Lead Local Flood Authority

Date 12 December 2023

RE: FP/274/21/OUT – Bognor Regis Golf Club, Downview Road, Felpham

Following a review of the submitted information we **object** to this planning application in the absence of an acceptable Flood Risk Assessment (FRA) & Drainage Strategy relating to:

1 in 100 year + 25% Climate Change
1.2m Sea Level Rise
Rainfall Applied on Site
Flood Depth Impact

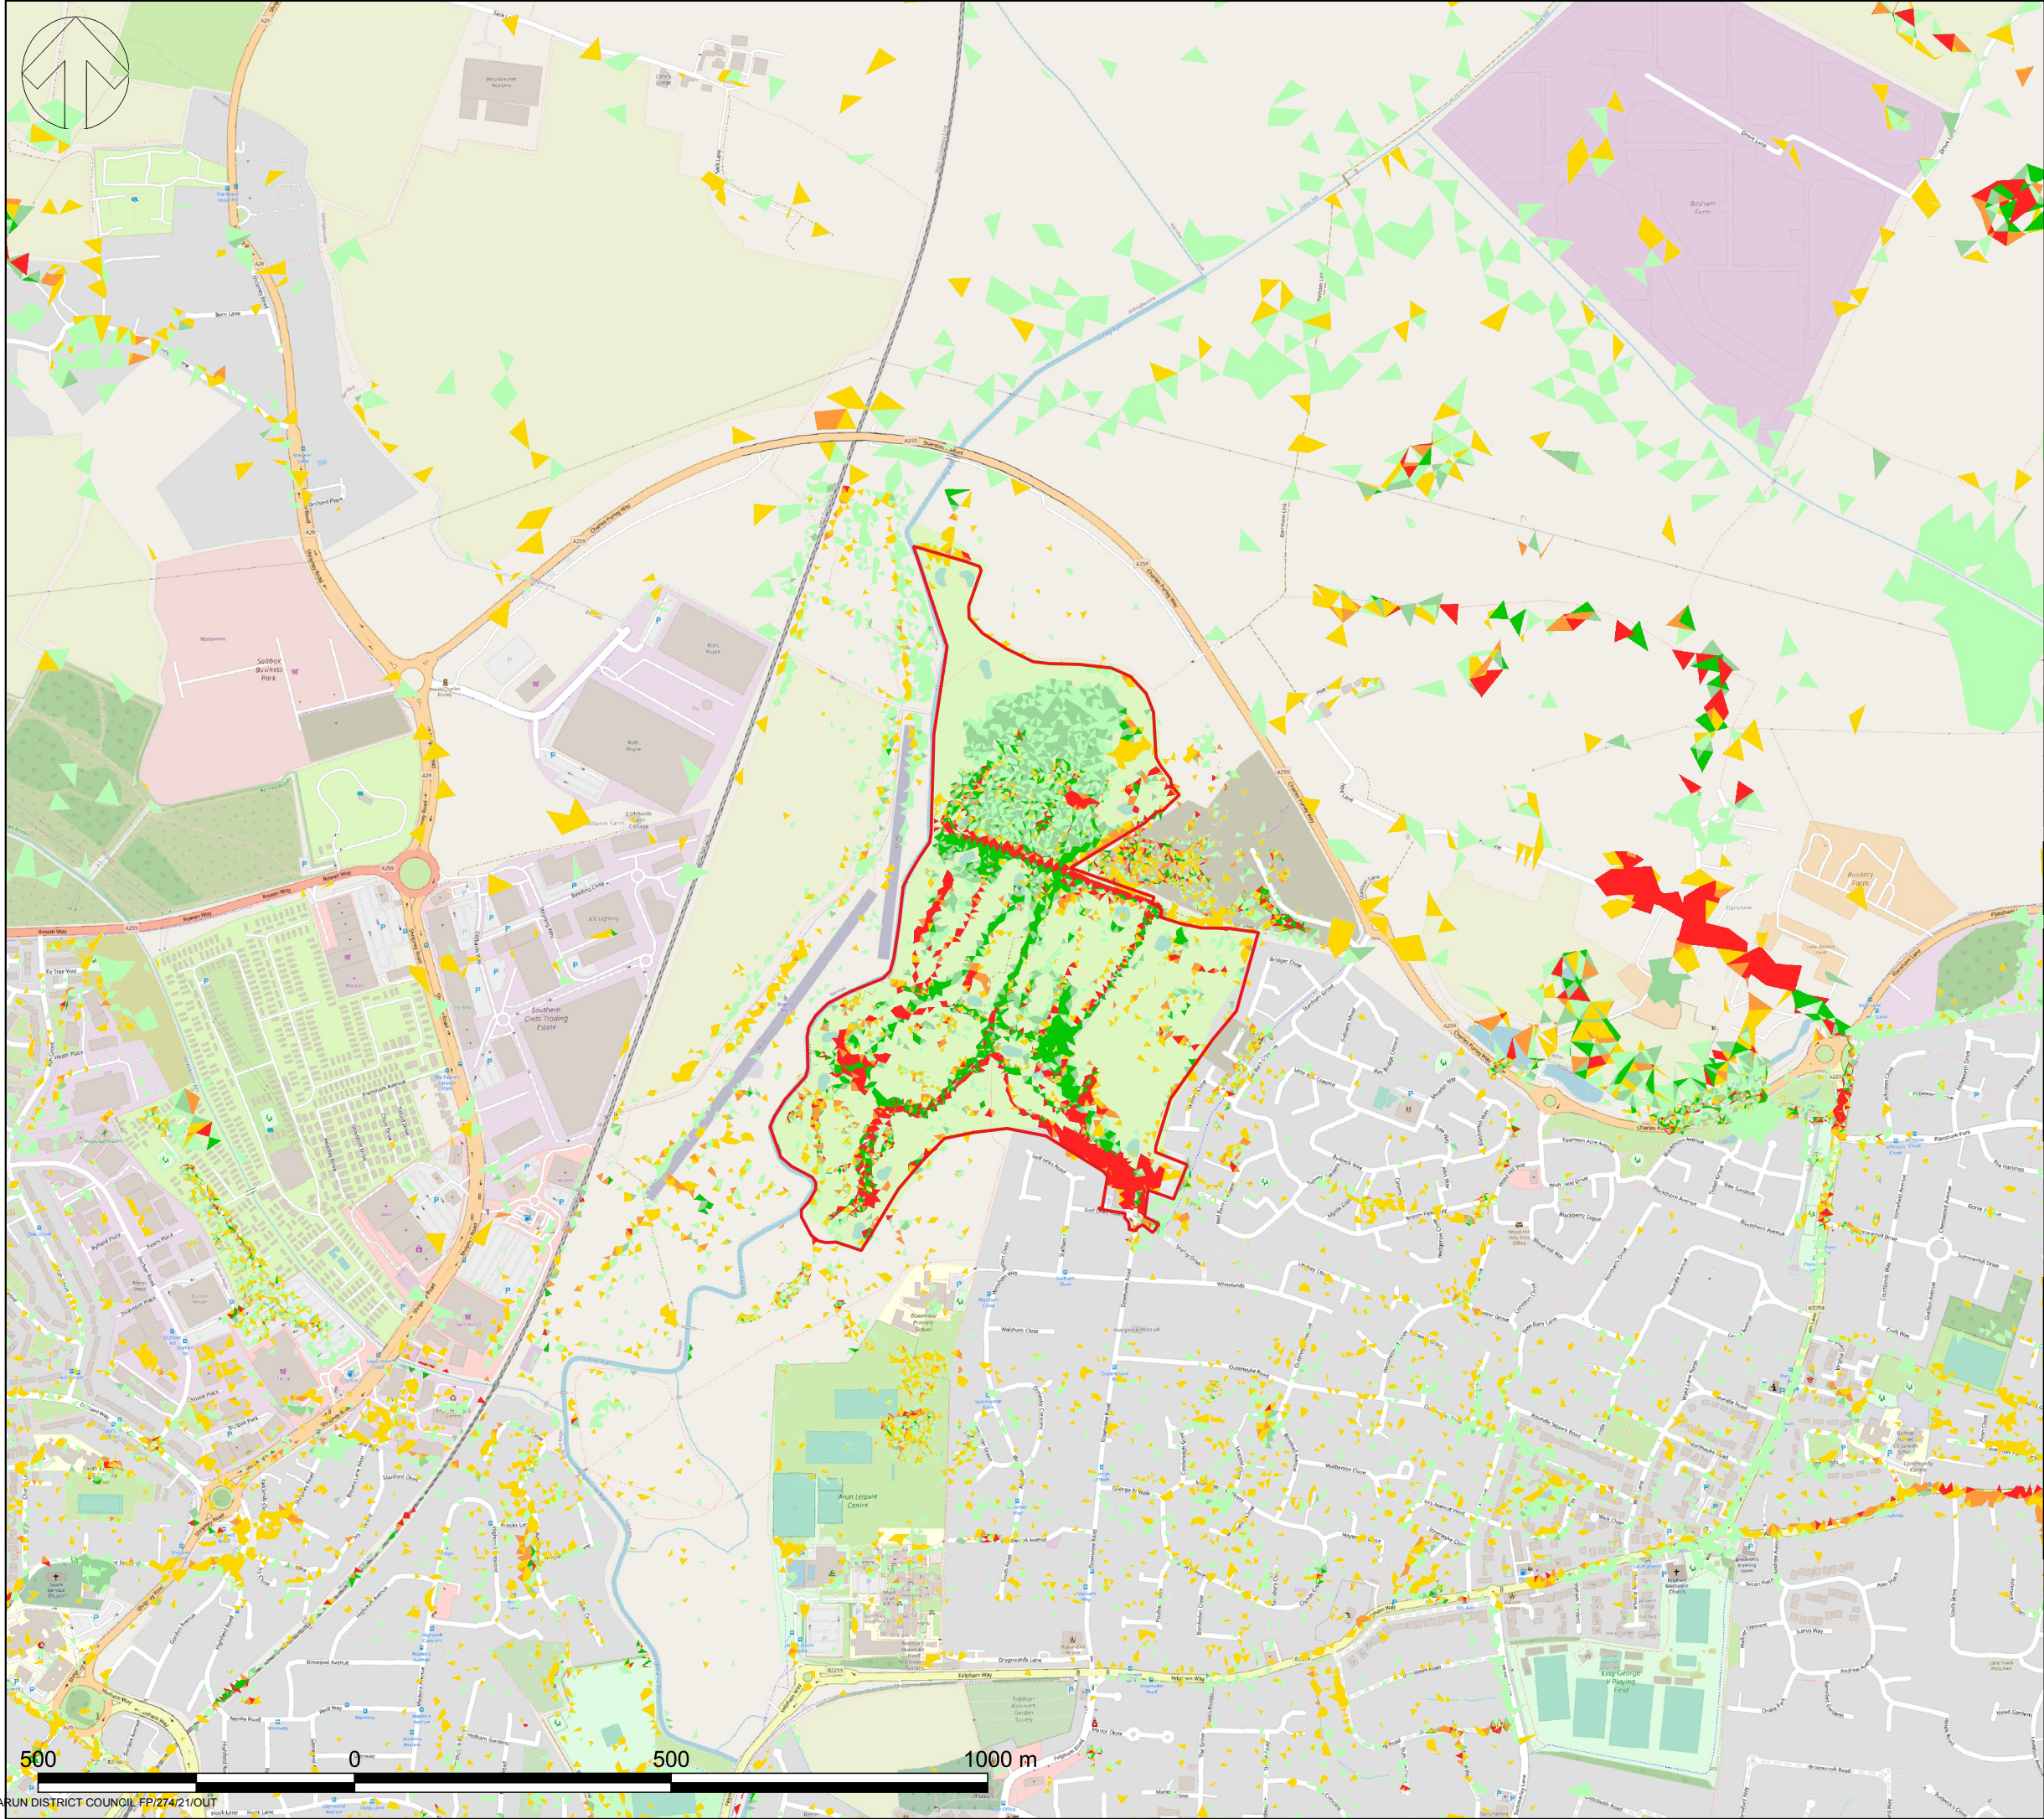
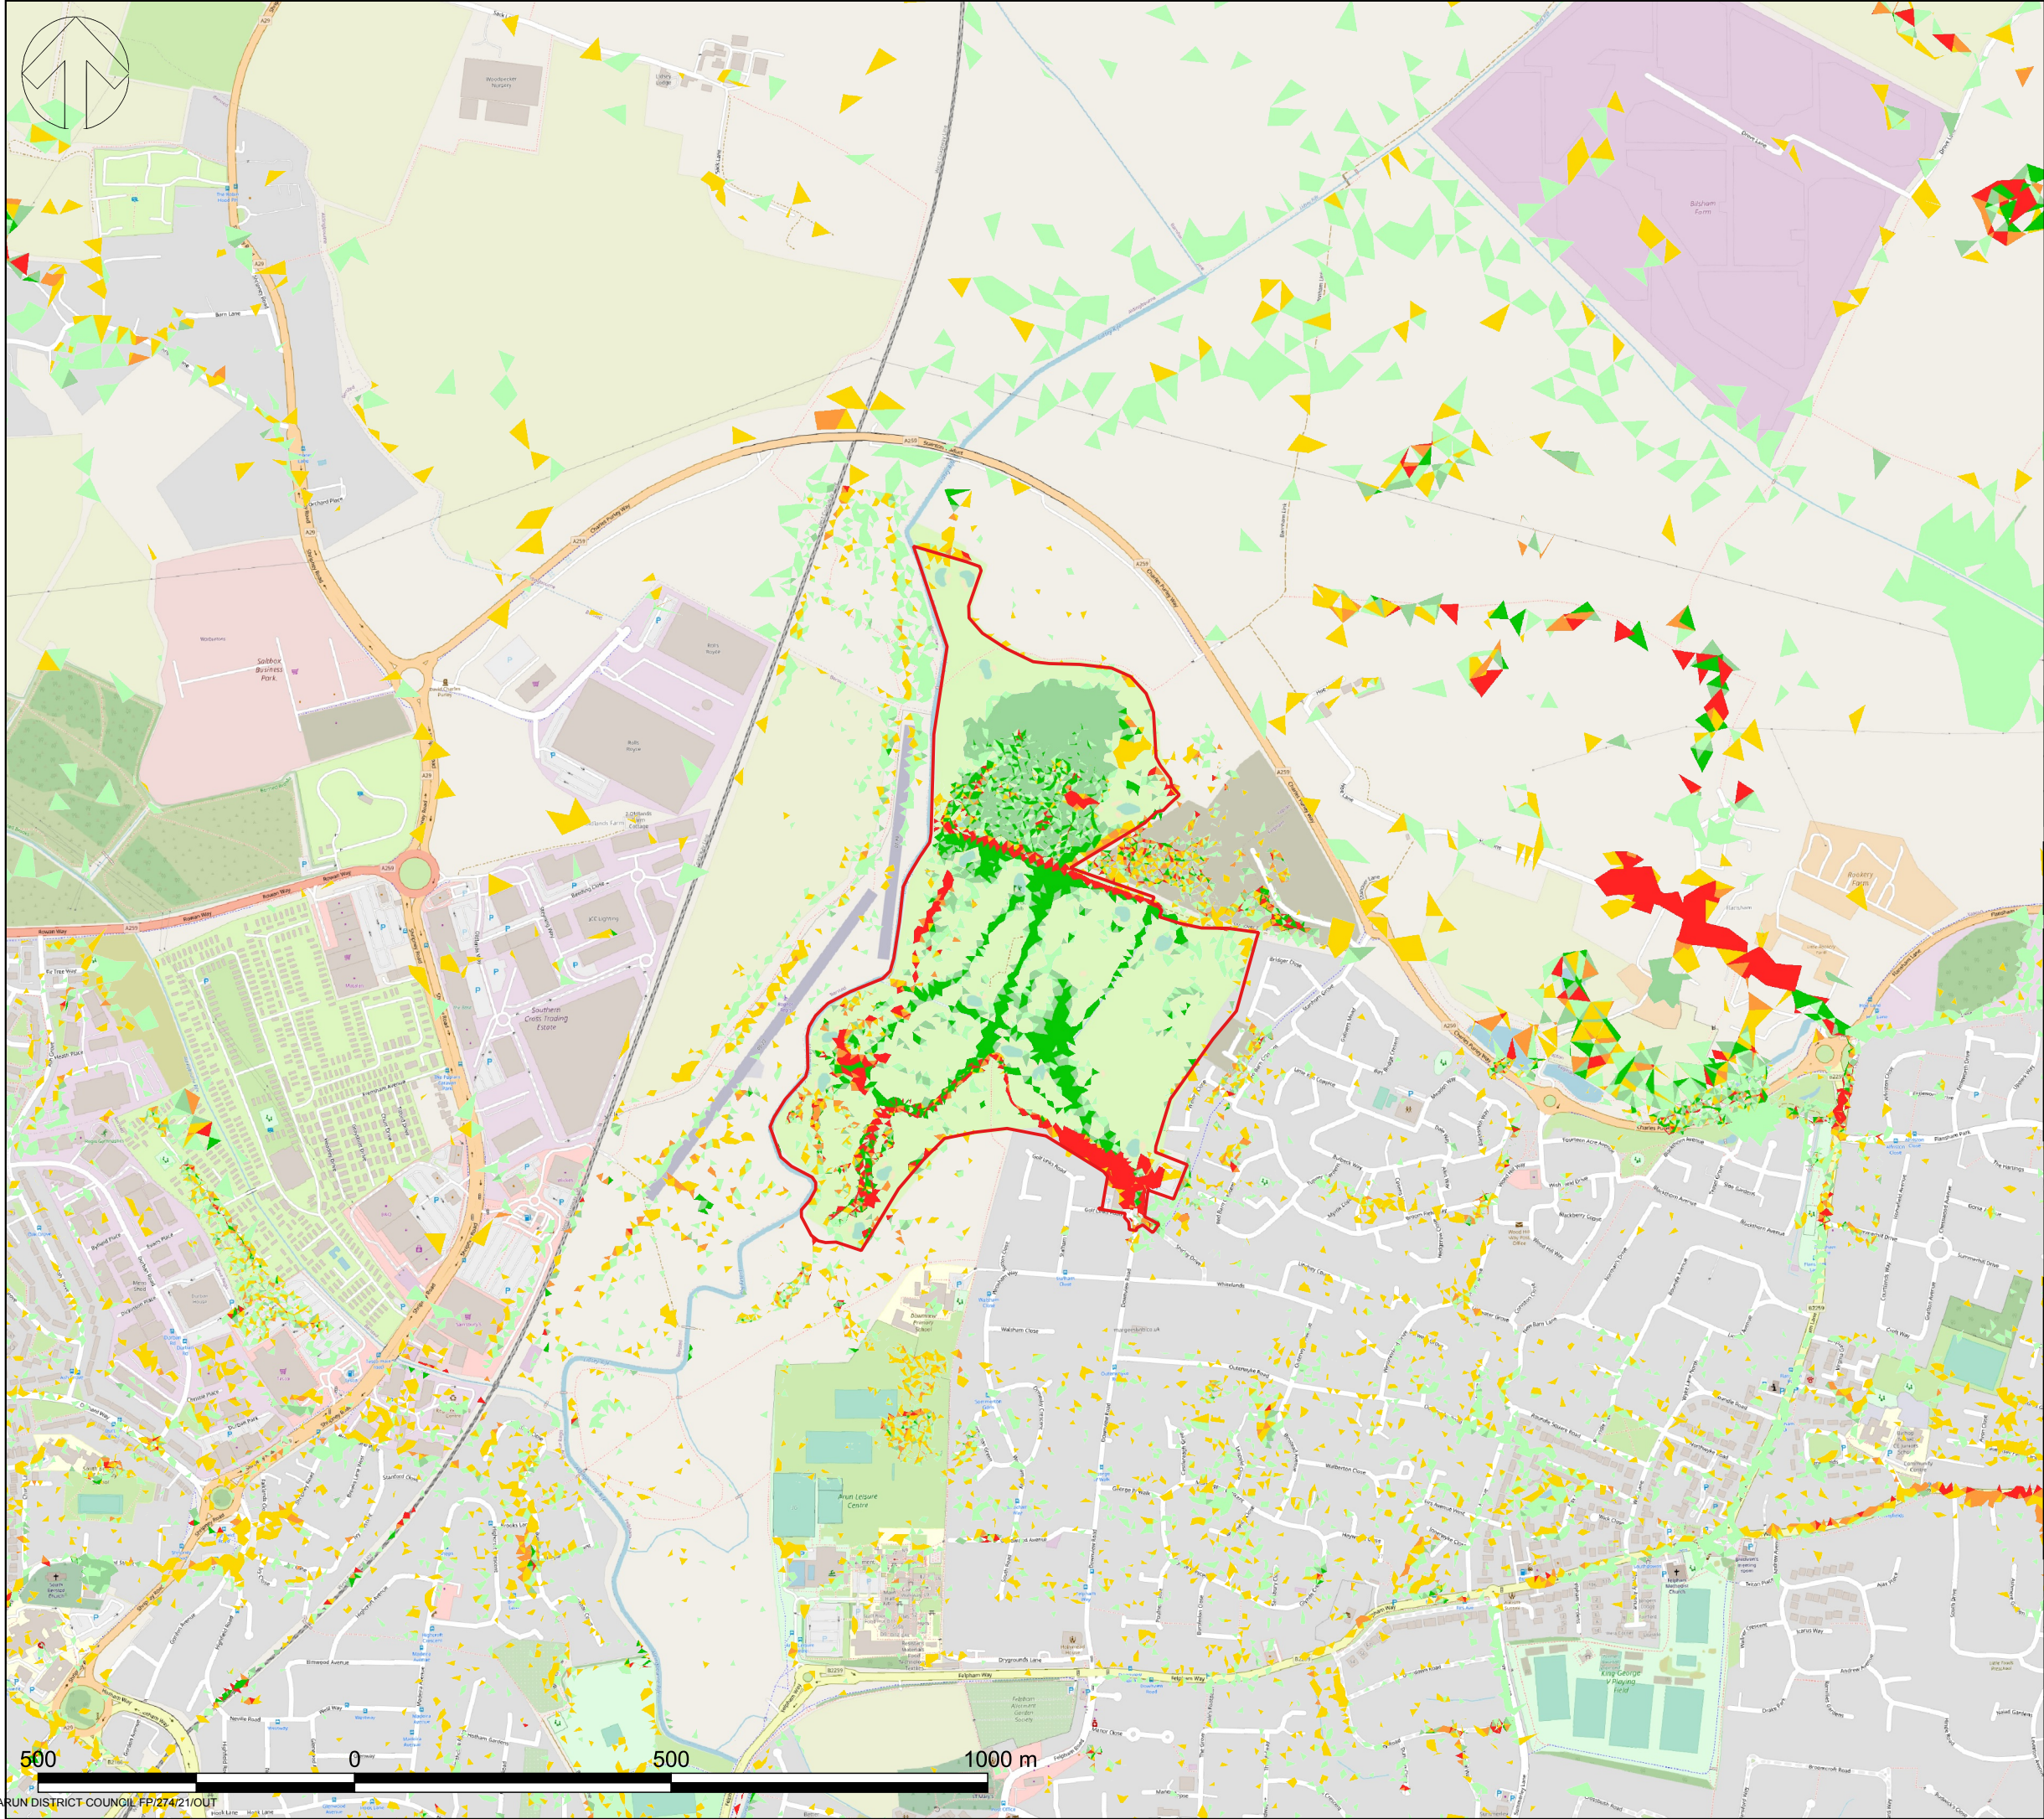
The original information does carry out further modelling however this concentrates on the fluvial flood risk and existing channels and is not detailed enough to clarify the Surface water flood risk to the site. It is also noted that the additional hydraulic modelling only utilises a 25% increase for climate change, in relation to surface water flood risk this should be increased to 45% as it's the current standard. The model will need to be updated to assess the surface water flow paths coming through the site and not only those represented by the channels. It is not appropriate to use out of date data at the time of determination of a planning application and hence an update was provided when the NPPF PPG was updated in the form of a technical note however the applicant has failed to update the climate change allowances and modelling parameters which are also out of date at this present time and therefore underestimates the risk of flooding to the site. The modelling and assessment also needs to demonstrate that there is no development within the 1 in 30 (3.33%) AEP for both surface water and fluvial as this is now considered the Functional Floodplain with NPPF since the update in August 2022.
